Memorandum – Traffic

File No. State Significant Development: SSD10421

Address NEILD AVENUE RUSHCUTTERS BAY 2011

A new Weigall sports complex for Sydney Grammar School comprising demolition of structures, construction of three-storey and single-storey building. Ancillary works involving landscaping, tree removal, kiosk substation, car parking and signage

Drawing Title
BUILDING 02
CAR PARK
GENERAL ARRANGEMENT PLAN
LOWER/UPPER GROUND
Sheet Status
NOT FOR CONSTRUCTION

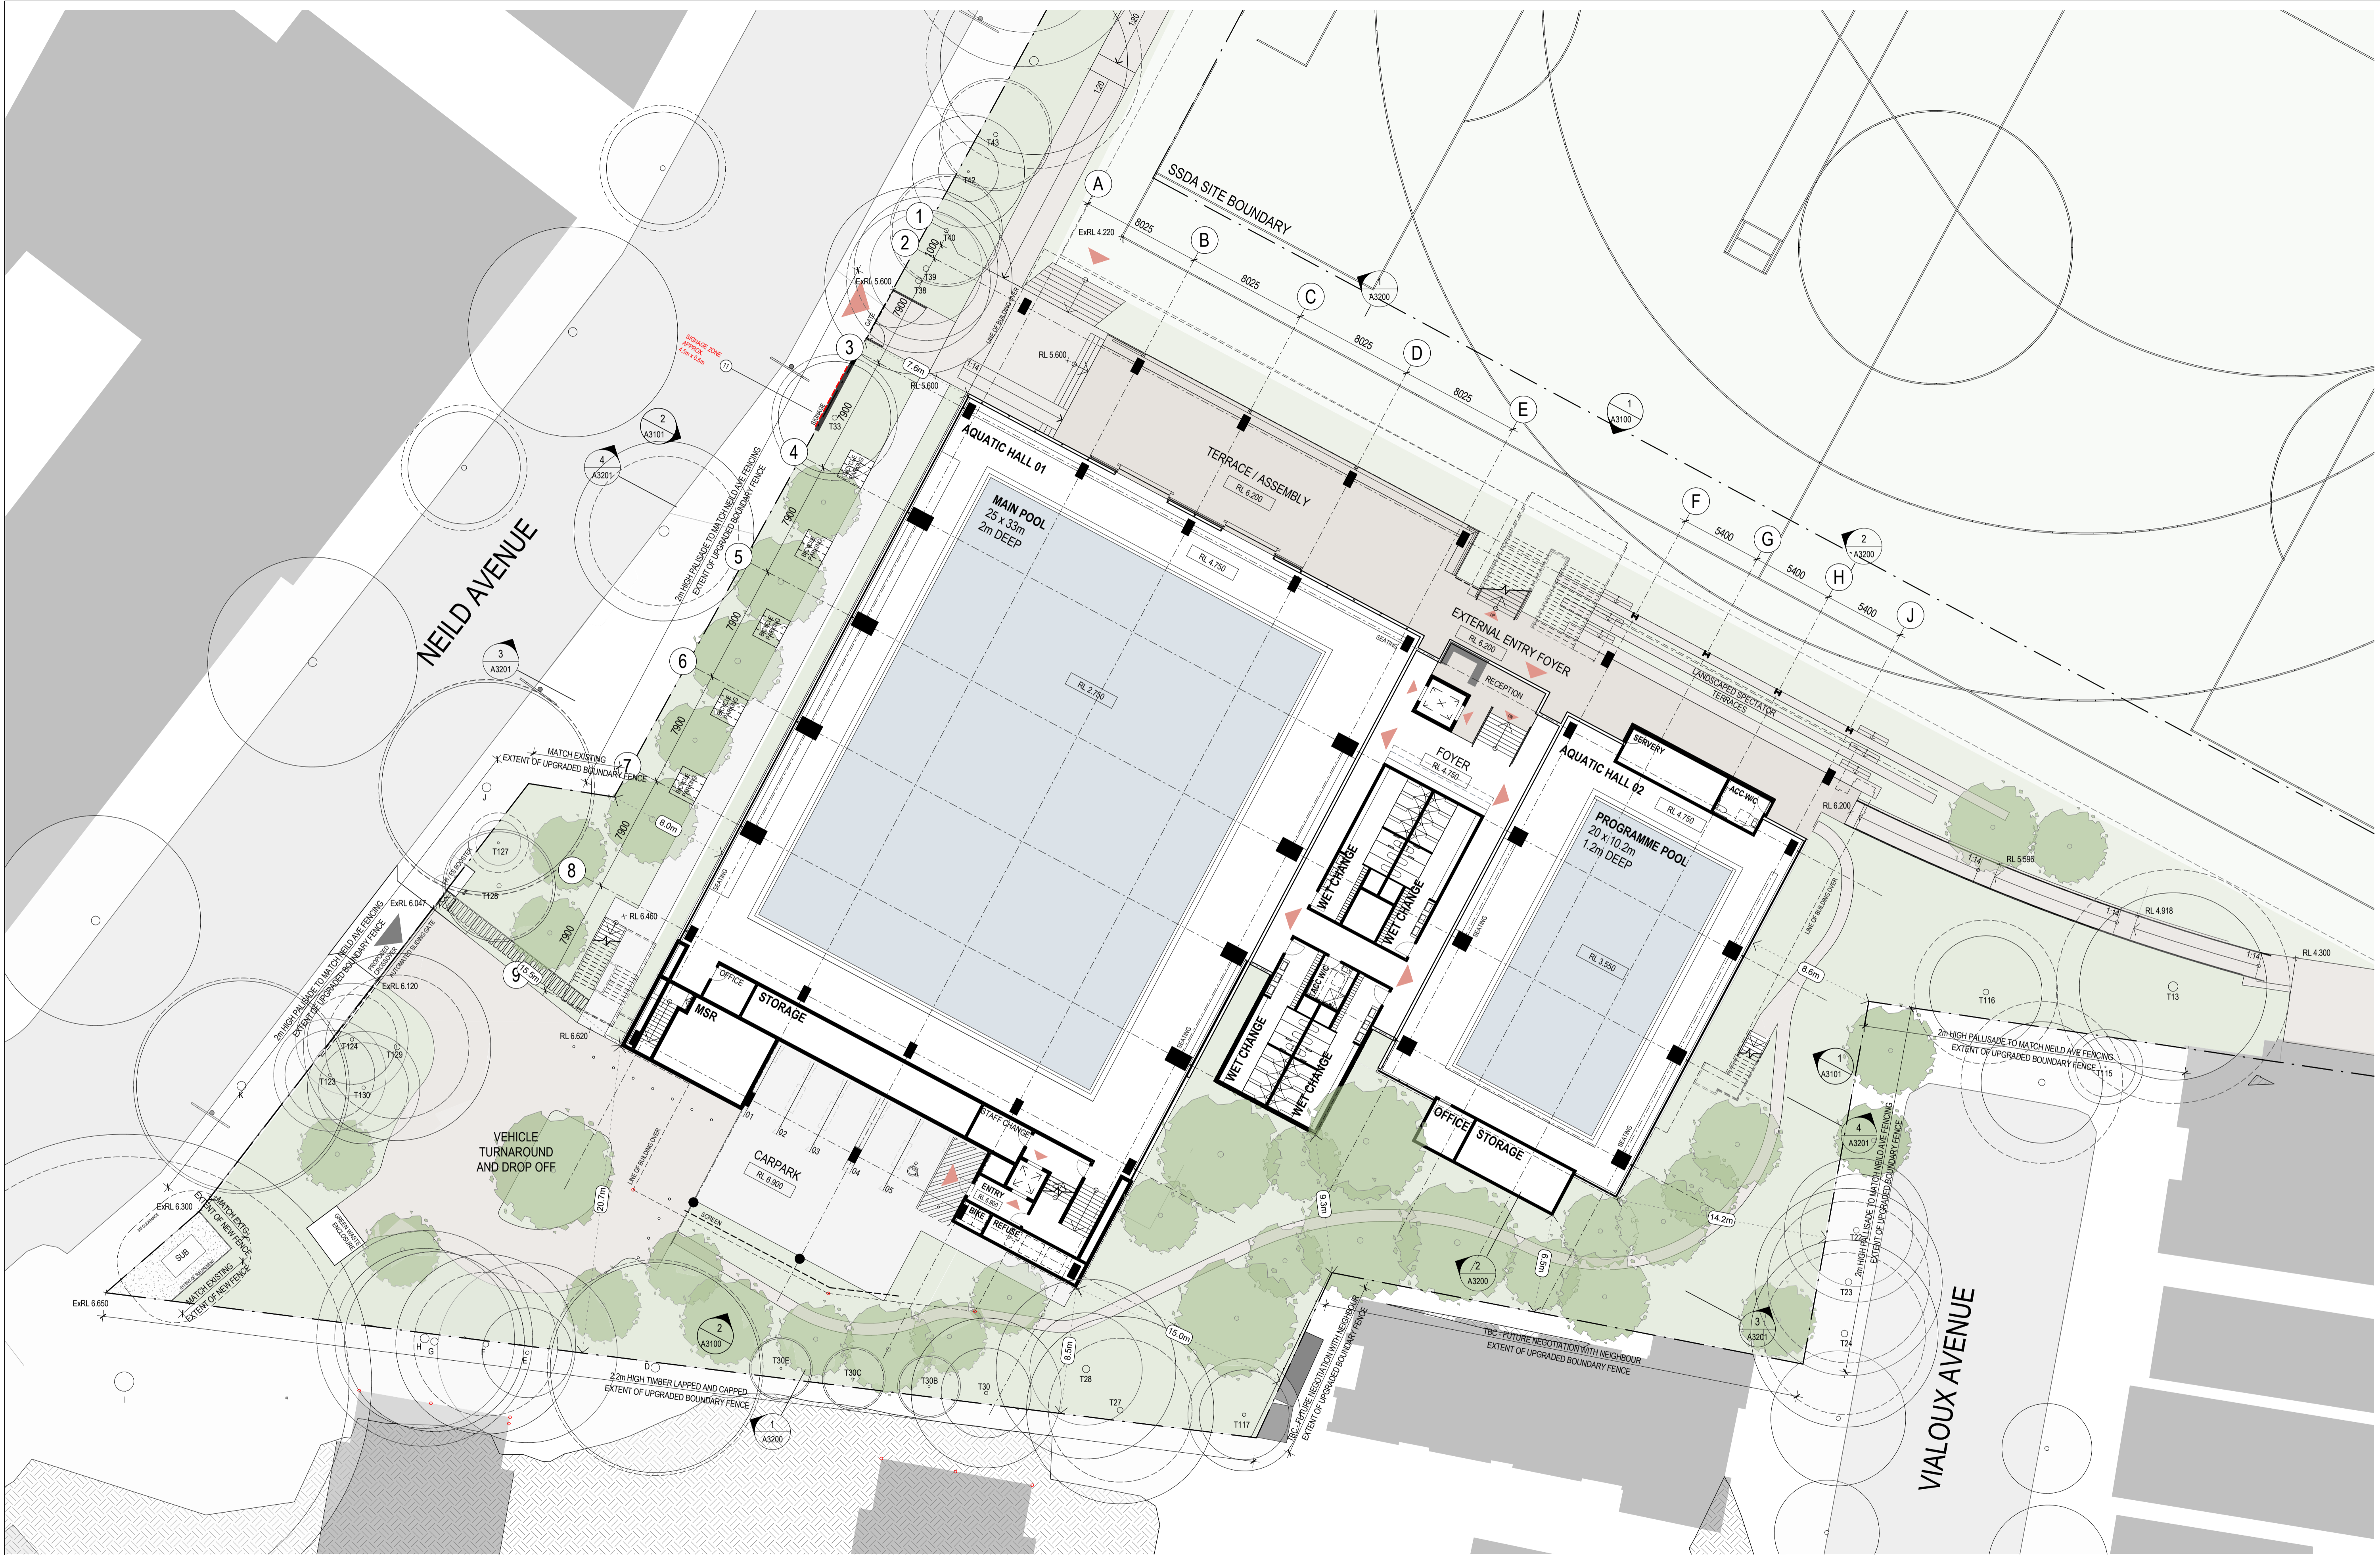
While Traffic Section in principle agrees with the assumed mode splits, average service time and duration of pick-up/drop off period, a more quantifiable queuing analysis should be submitted to demonstrate the proposed on-site pick-up/drop-off circulation area can accommodate 98th percentile queue at peak traffic levels. It should be noted that vehicles must not wait on the footpath or roadway.

For pick-up/drop-offs of the preparatory school, providing on-site circulation inside the proposed car park to accommodate the existing queue would alleviate congestion along Alma Street, and should be encouraged. As discussed above, staff parking demand during weekdays will be relatively low, and given the nature, turnover rates for the occupied spaces will be negligible, it is therefore envisaged that the proposed pick-up/drop-off circulation would not impact adversely on the on-site parking and is deemed satisfactory.
